# ENG-CDR21013-R3-FDR.pdf Markup Summary

Briargate Bridge at Sand Creek at Sterling Ranch  
Cost Comparison

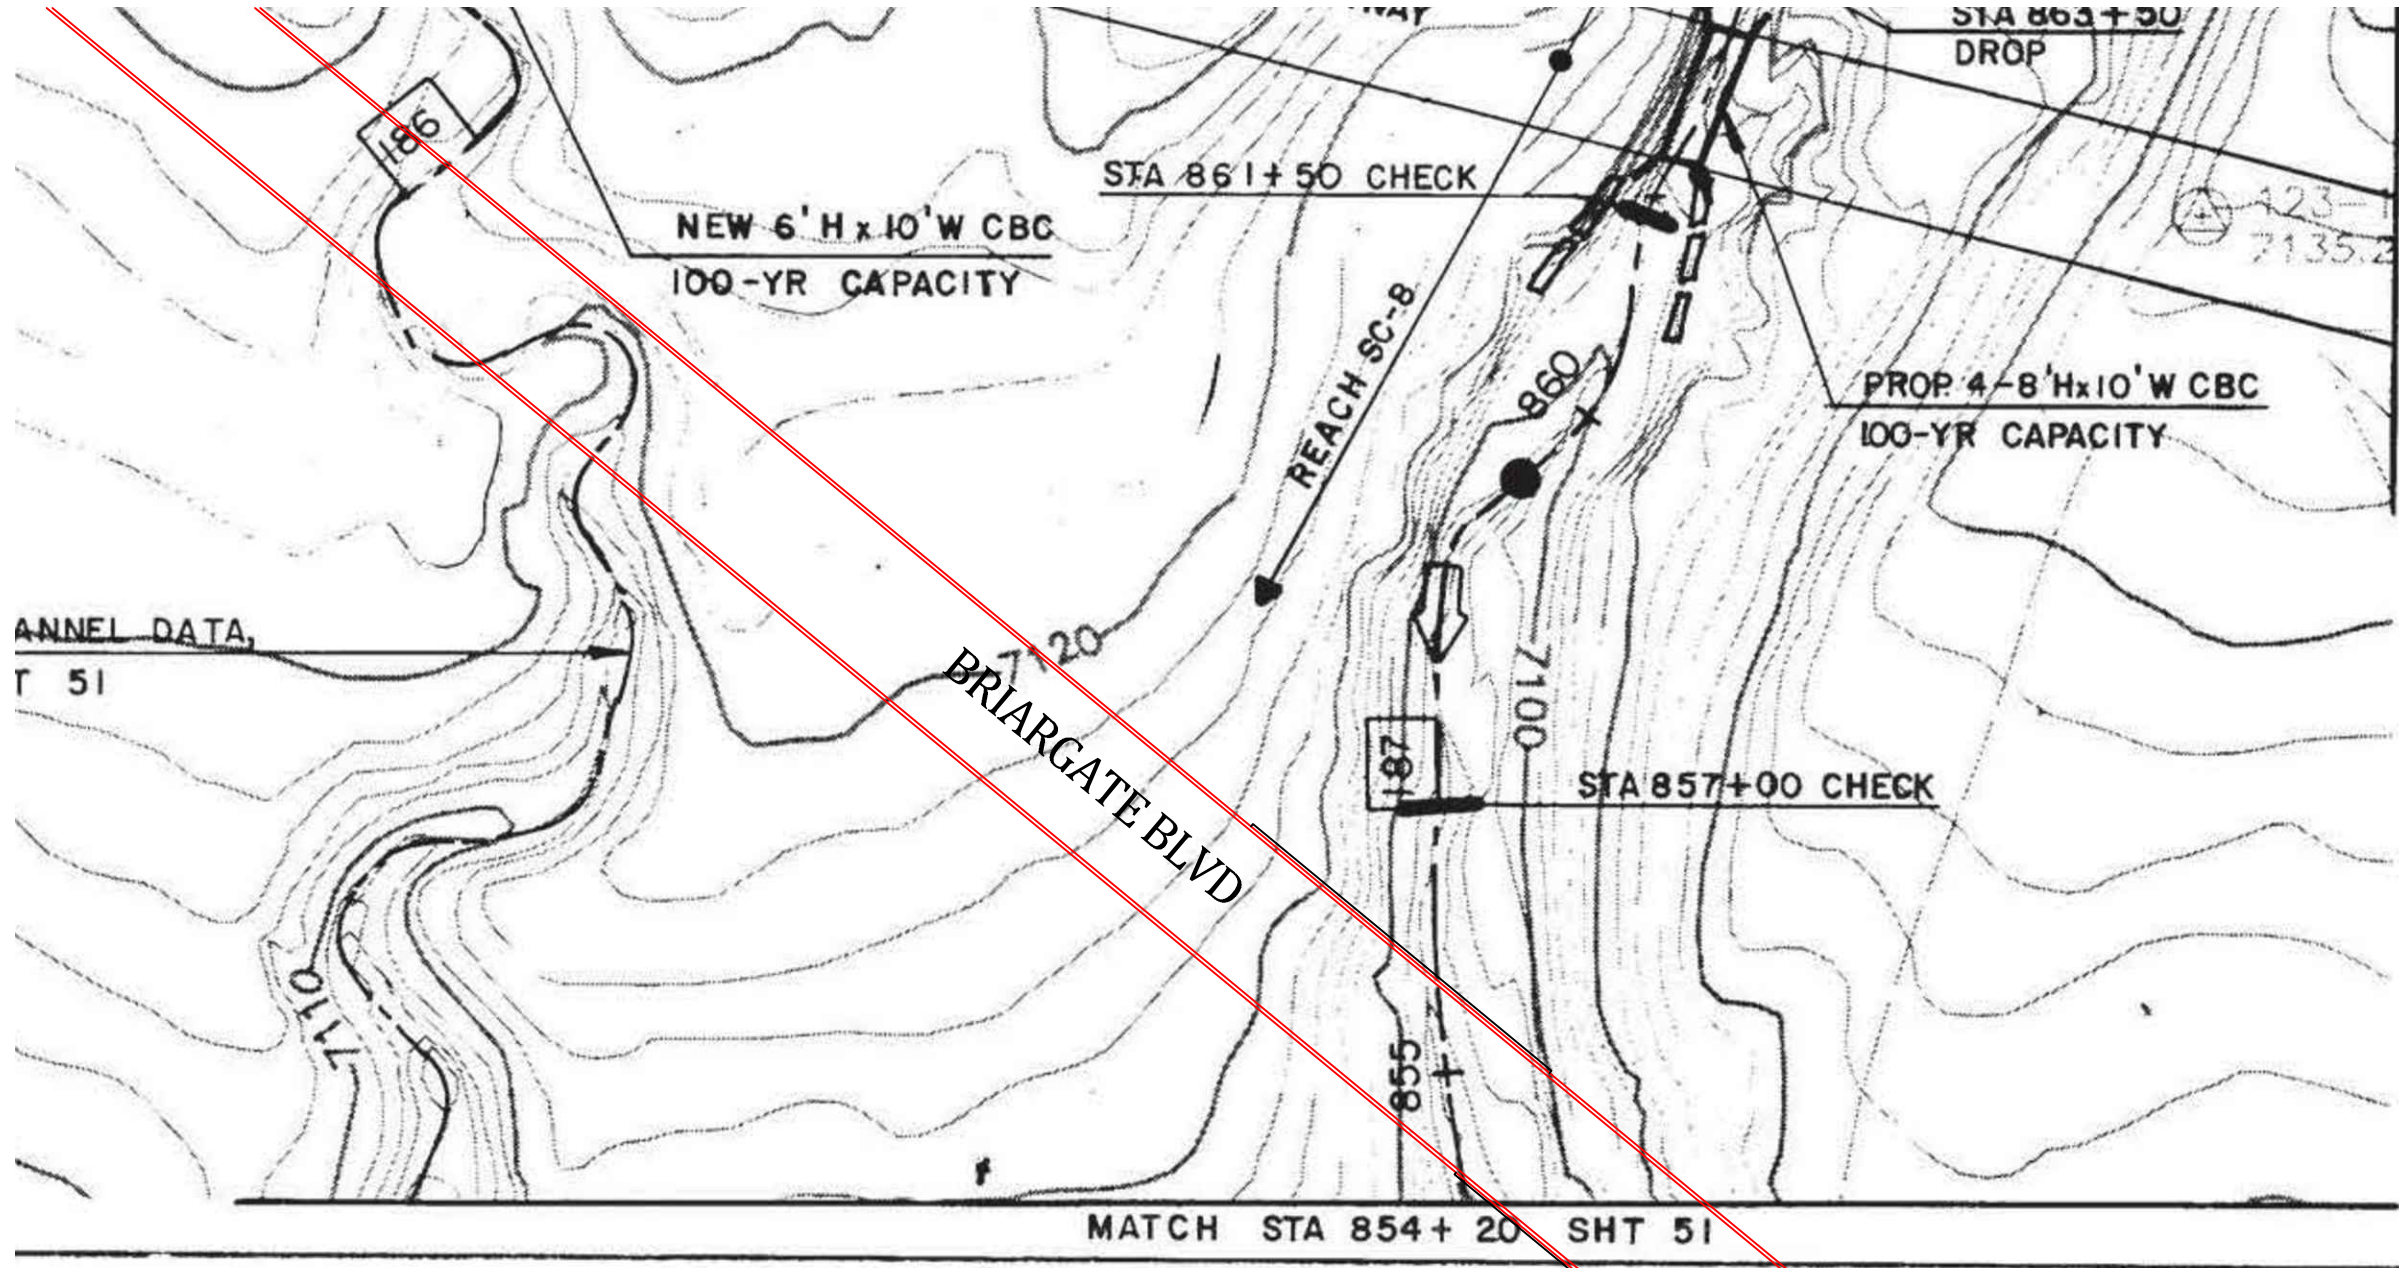
Use the 1996 DBPS costs and provide excerpts.  
Discuss the current cost of the proposed design.

**STERLING RANCH DEVELOPMENT
BRIARGATE BOULEVARD BRIDGE CONSTRUCTION DRAWINGS
STRUCTURE LAYOUT**
EL PASO COUNTY, COLORADO

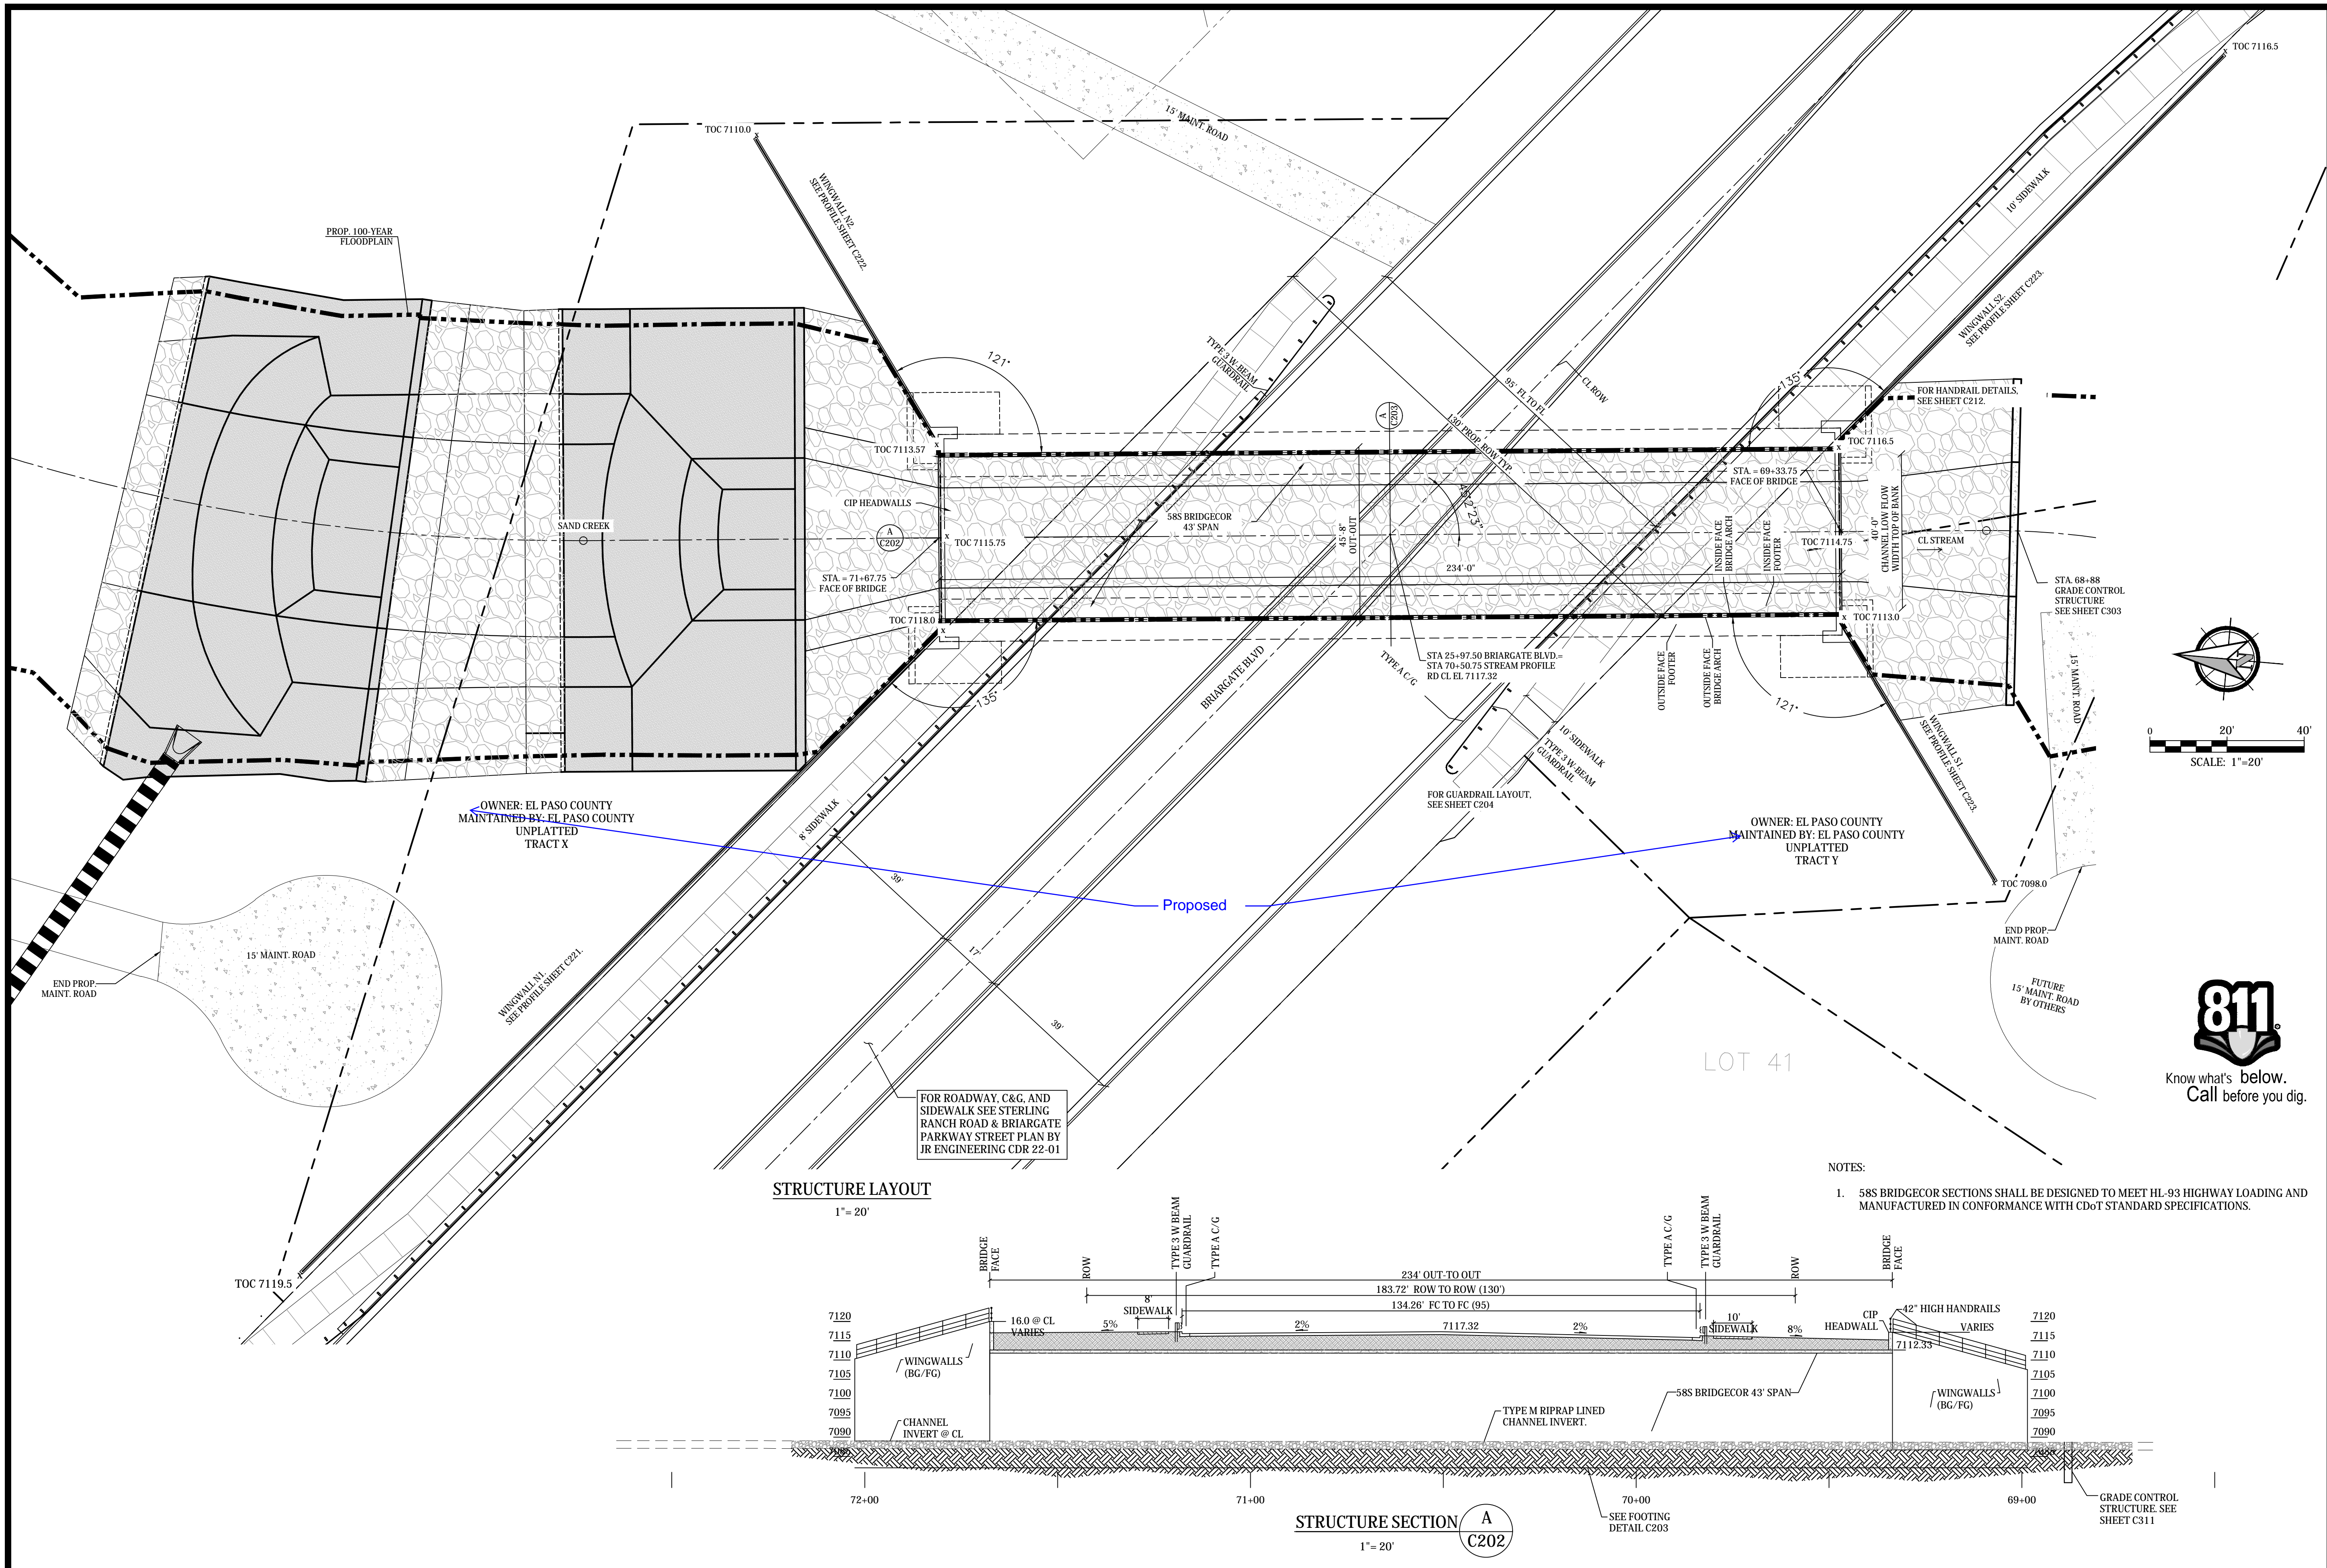
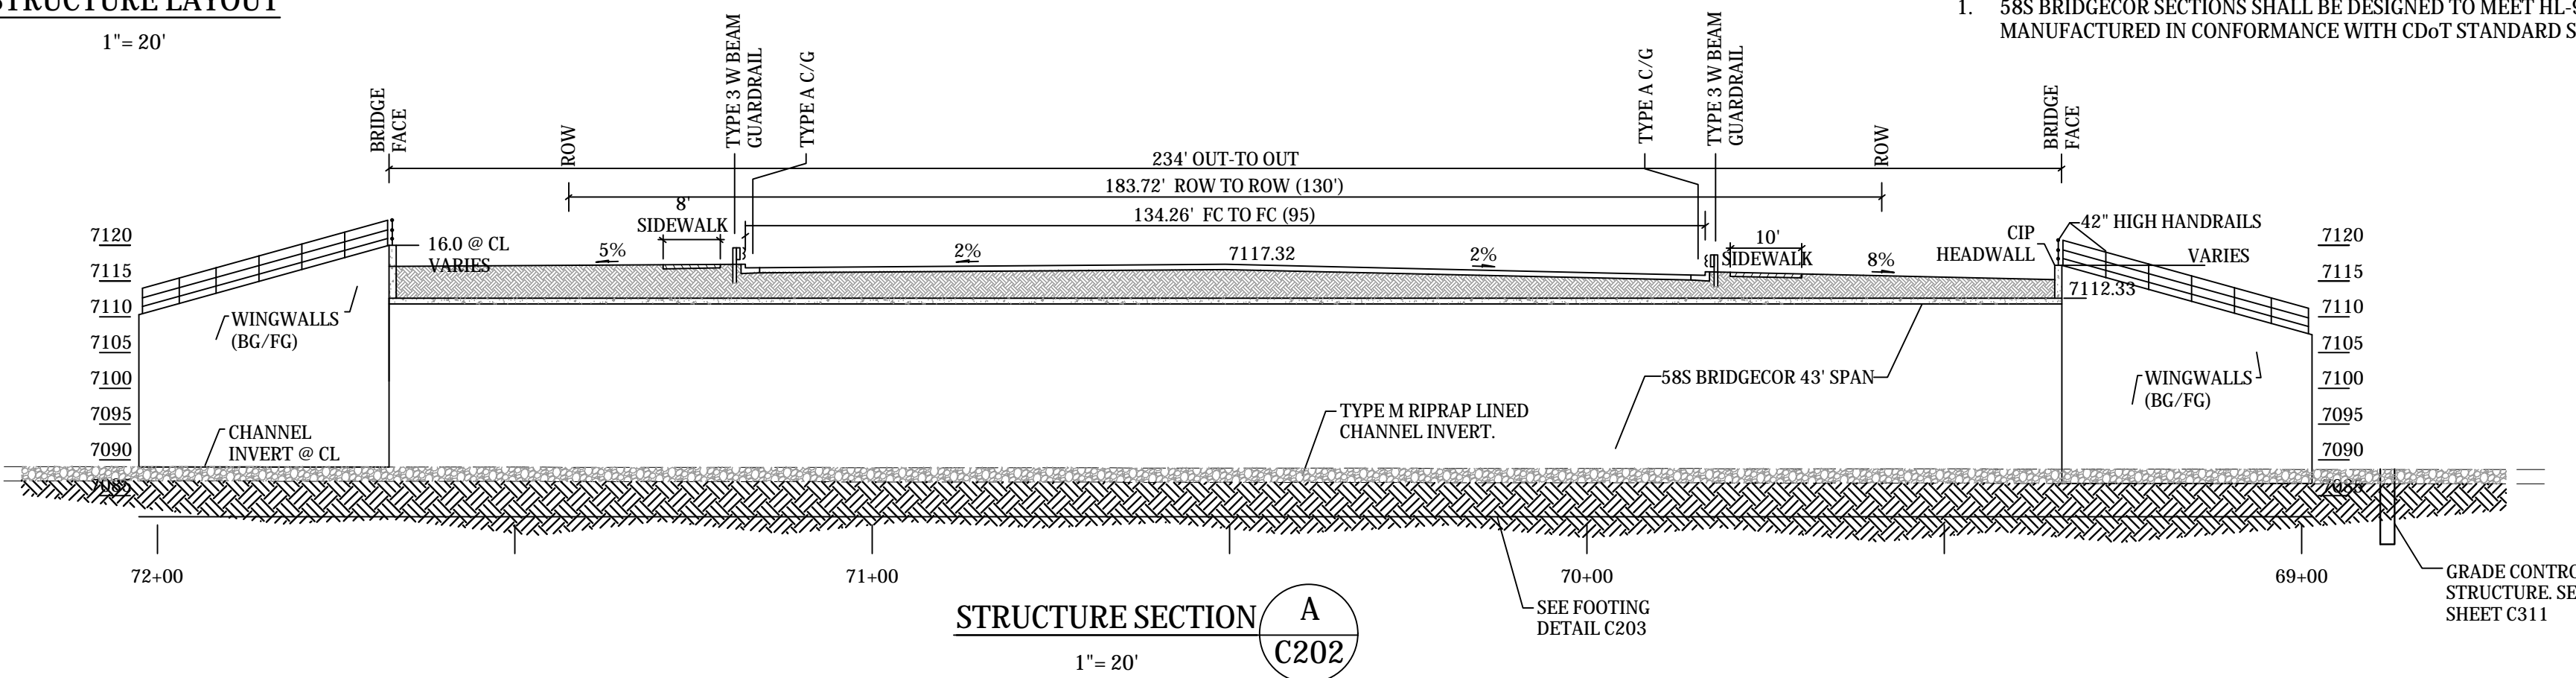
58S?

58S?
